Rezoning Transportation Analysis
Petition Number: Insert Zoning Petition #2021-206
General Location Identifier: 04729144

Date	Description
01-27-22	First Review (TM)

The petition is located adjacent to Olmsted Drive, a City-maintained local street and Tryon Street a State-maintained major thoroughfare. A Traffic Impact Study (TIS) is not needed for this site, because the proposed site will generate less vehicular trips than what is entitled with the current zoning/land use. Site plan revisions are needed to meet ordinance requirements and/or the outstanding items including, but not limited to installing ADA compliant curb ramps at the driveway connections on Olmsted Drive, labeling the internal proposed streets as private, and dimensioning and labeling the proposed and existing sidewalks and planting strips on and adjacent to the property. Further details are listed below.

REZONING PETITION 2021-206  
RZ-2 : TECHNICAL DATA SHEET

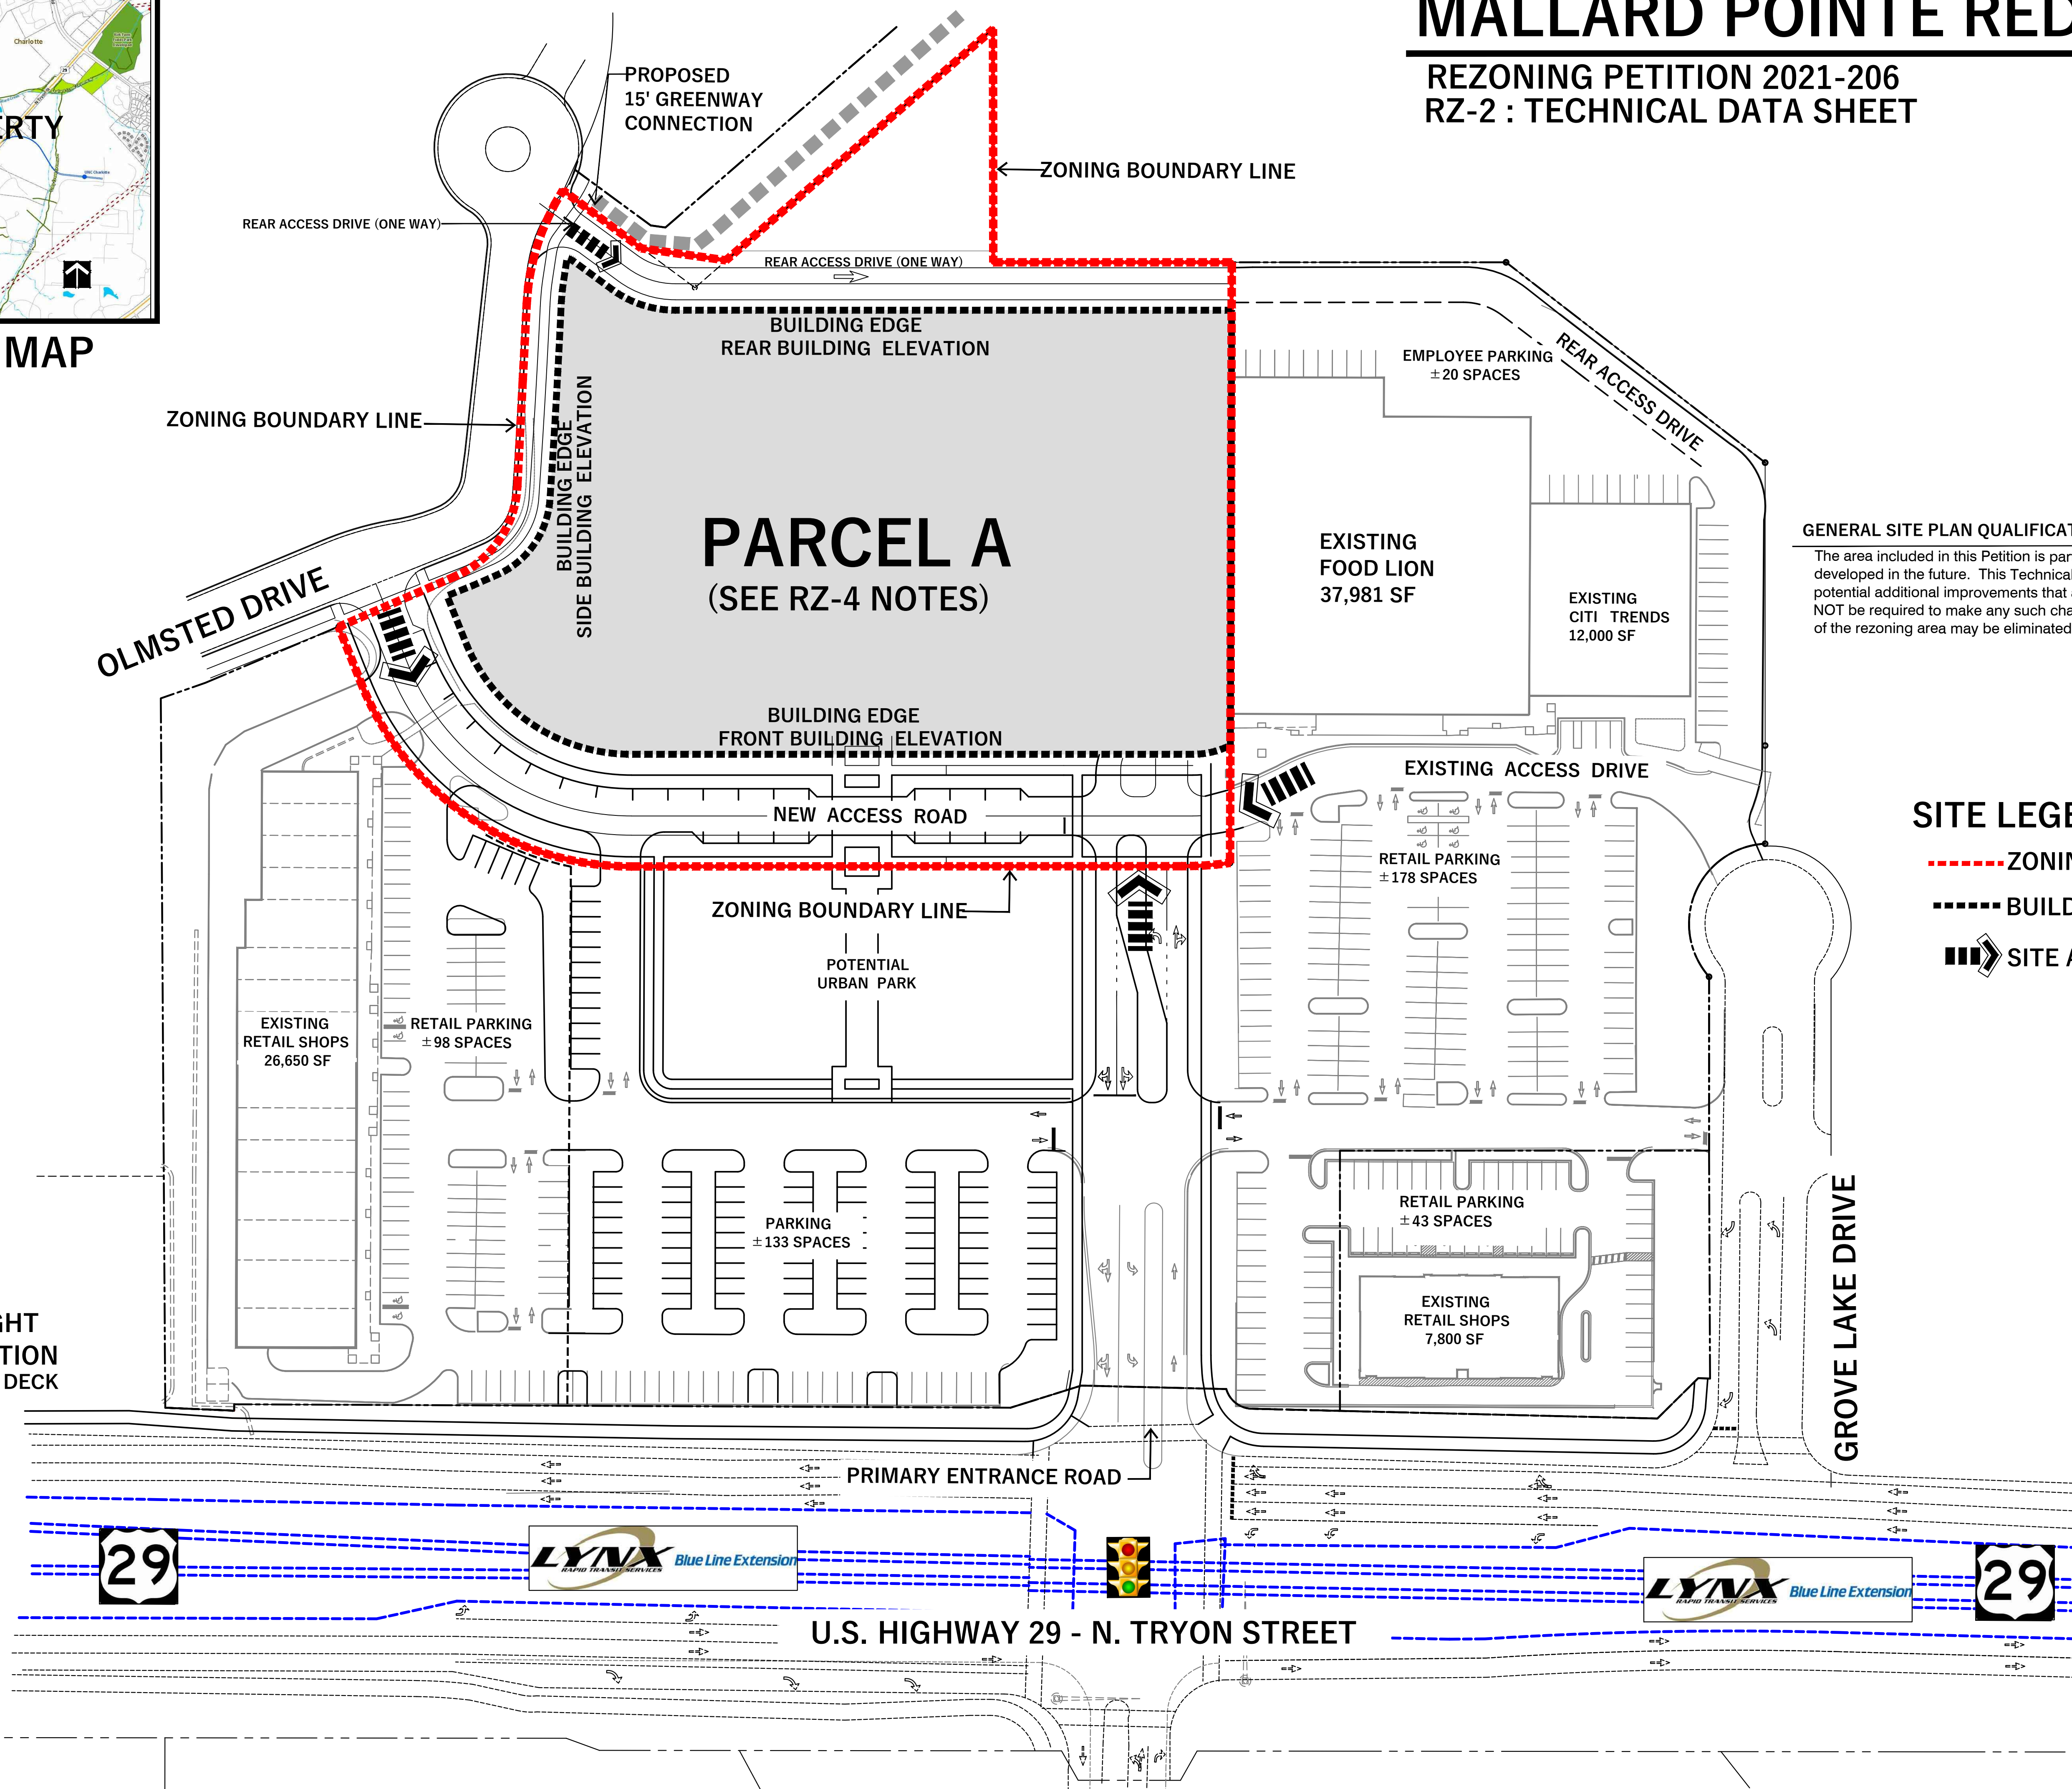
Label and dimension the curb and gutter from the centerline for each road on the site plan.
2. **Traffic Study:**
 A Traffic Impact Study (TIS) is not necessary for the complete review of this petition due to the site generating less than vehicular trips than what is entitled with the current zoning/land use.

3. Label and dimension the existing or proposed planting strip and sidewalk along the property frontage of Olmsted Drive to provide clarity. In addition, revise site plan and conditional notes to commit to installing curb ramps at the driveway connections or reconstruct the driveways as Type II Modified per CLDSM 10.25E.

4. The proposed dwelling units exceeds 12 per acre. Per Chapter 20 Subdivision ordinance, site plan and conditional note(s) revisions are needed to commit to construct an 8-foot planting strip, and 8-foot sidewalk along Olmsted Drive. The wider sidewalk also meets the Charlotte WALKS Policy. In lieu of constructing the wider sidewalk at the property frontage, CDOT is requesting sidewalk is installed to connect the existing sidewalk on the frontage of the petition to the sidewalk at the corner of the Olmsted Drive and J W Clay Boulevard intersection. An 8-foot planting strip and 8-foot sidewalk is preferred.

7. Label and dimension the sidewalk and planting strip widths on the proposed private streets. Dimension the back of curb from the centerline of the roadways.

REZONING PETITION: 2021-206  
RZ-3 : ILLUSTRATIVE SITE PLAN

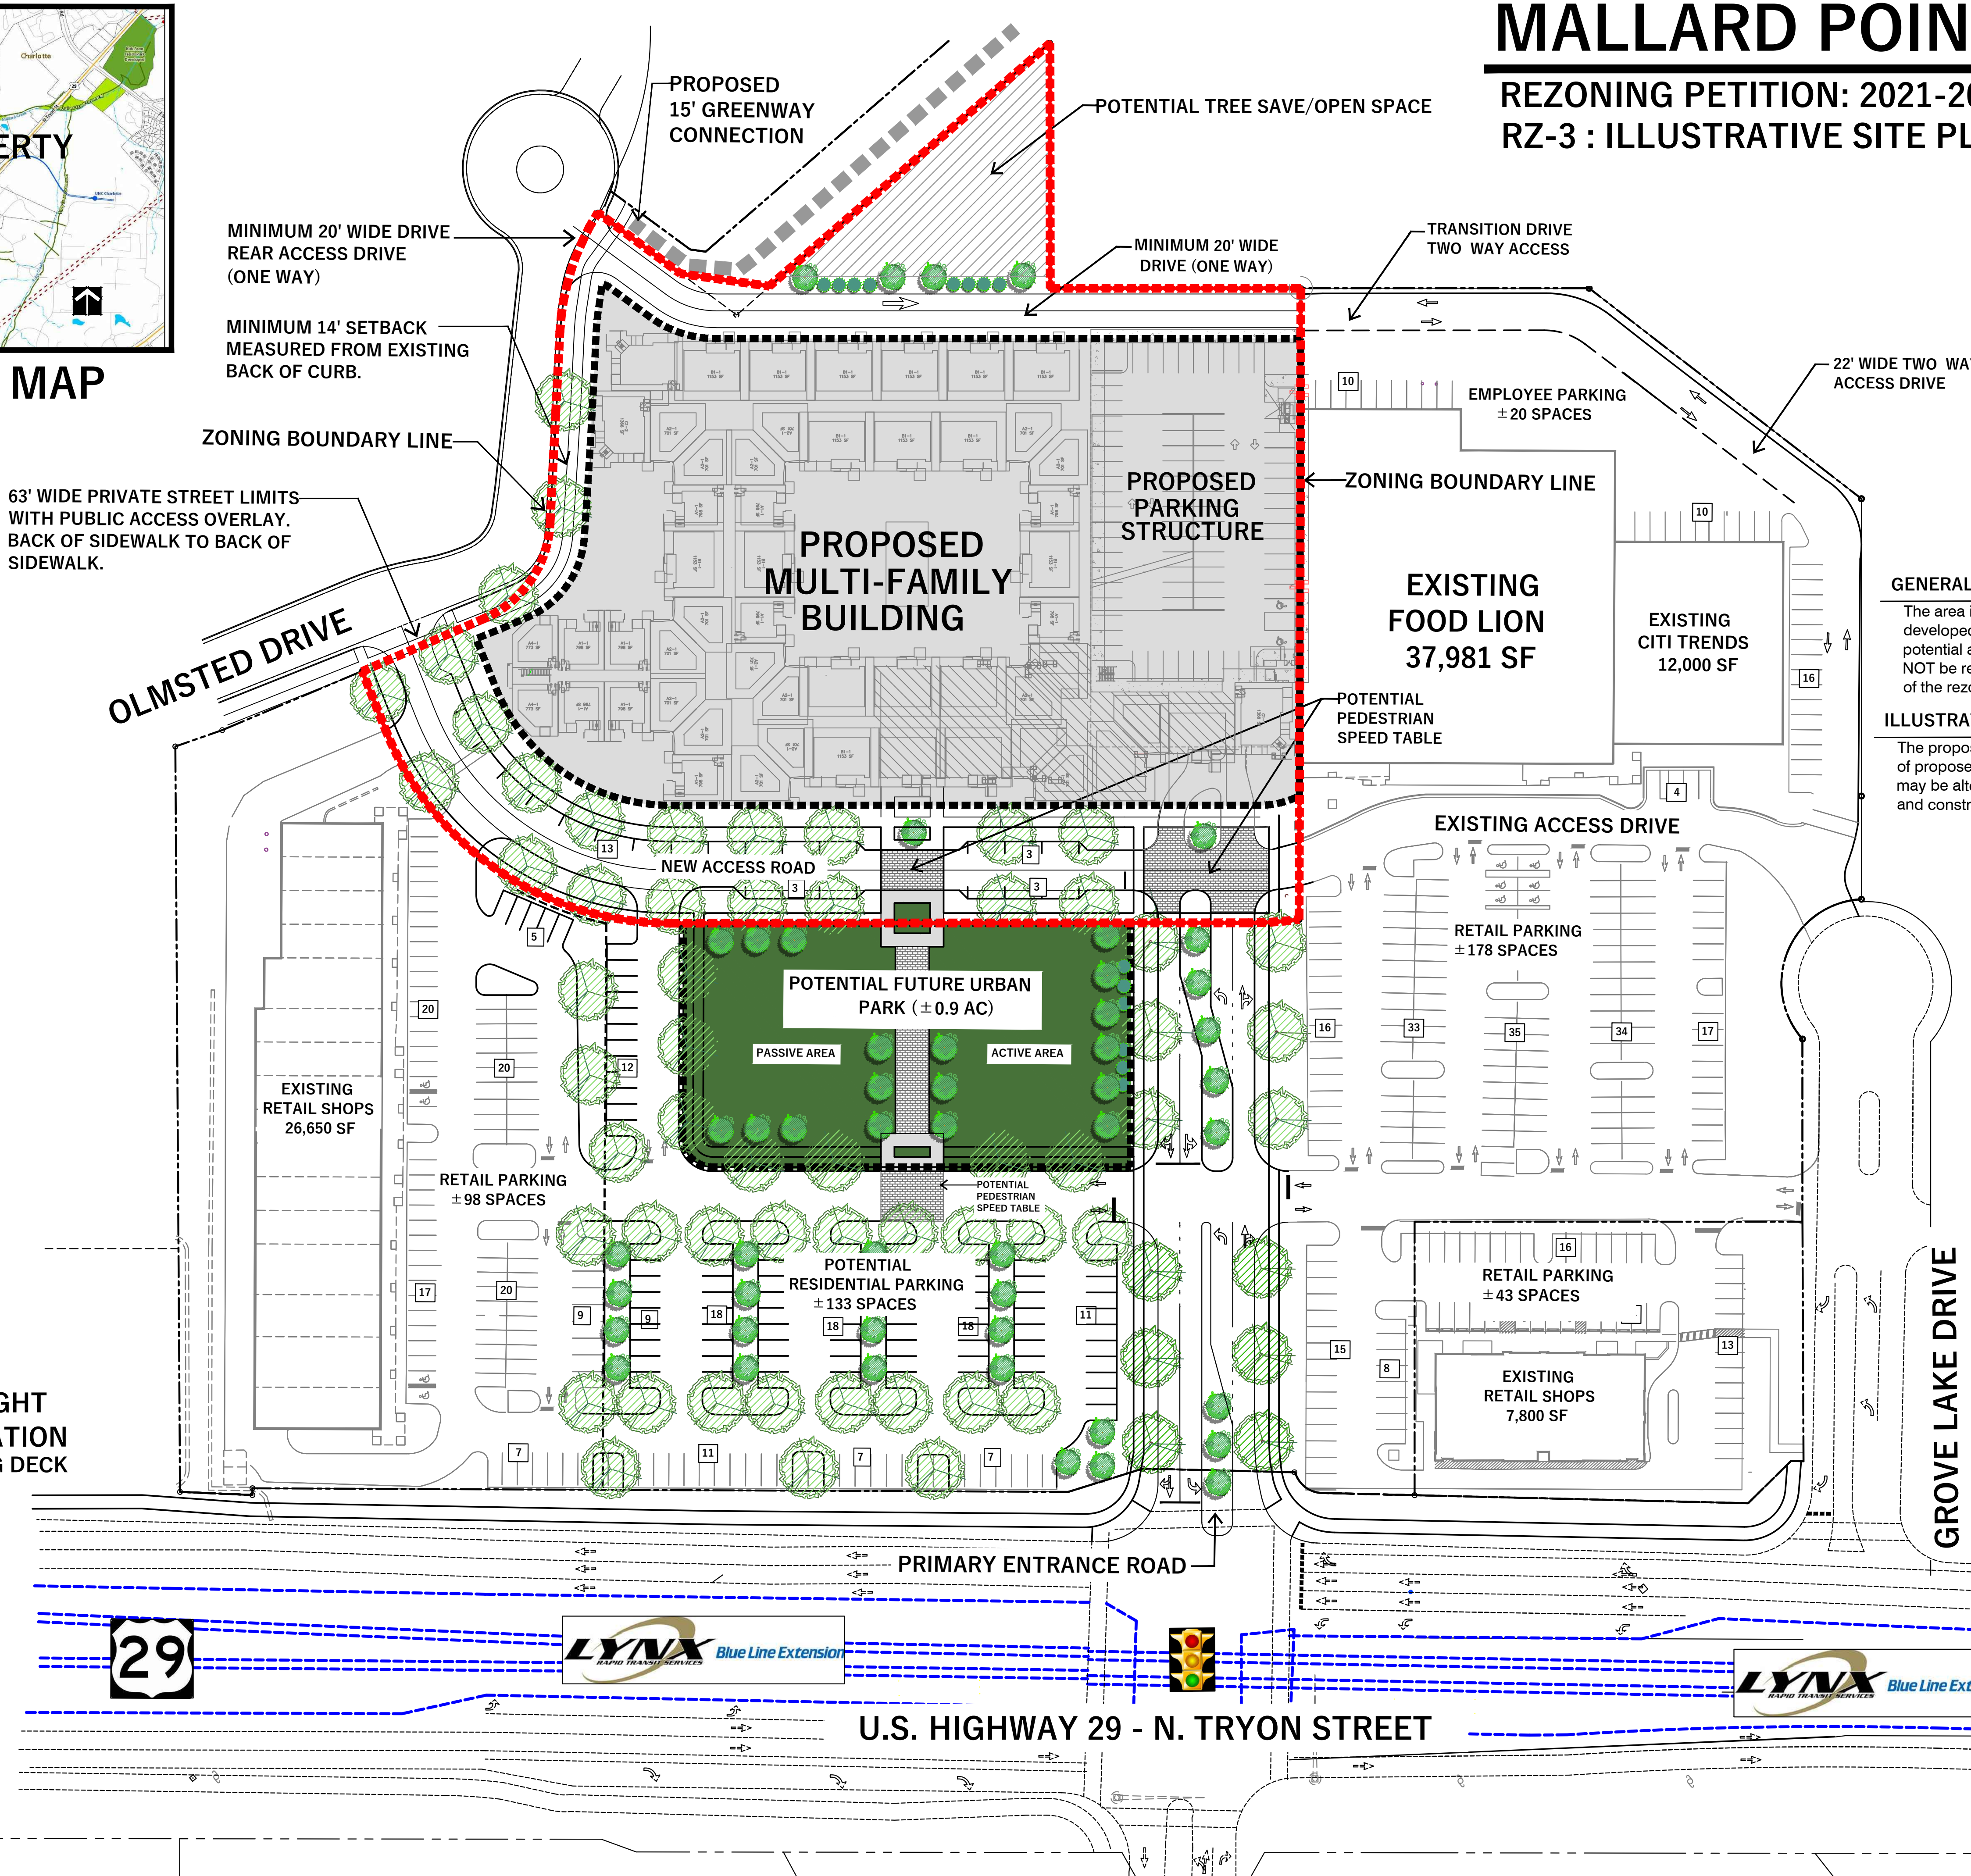
5. Label the proposed streets as private to provide clarity to the site plan. Add conditional note stating the roads are to be private.
6. Label and dimension the limits of the proposed public access easement on the private streets.

8. Extend the proposed sidewalk along the proposed northern street to the Olmsted Drive intersection.
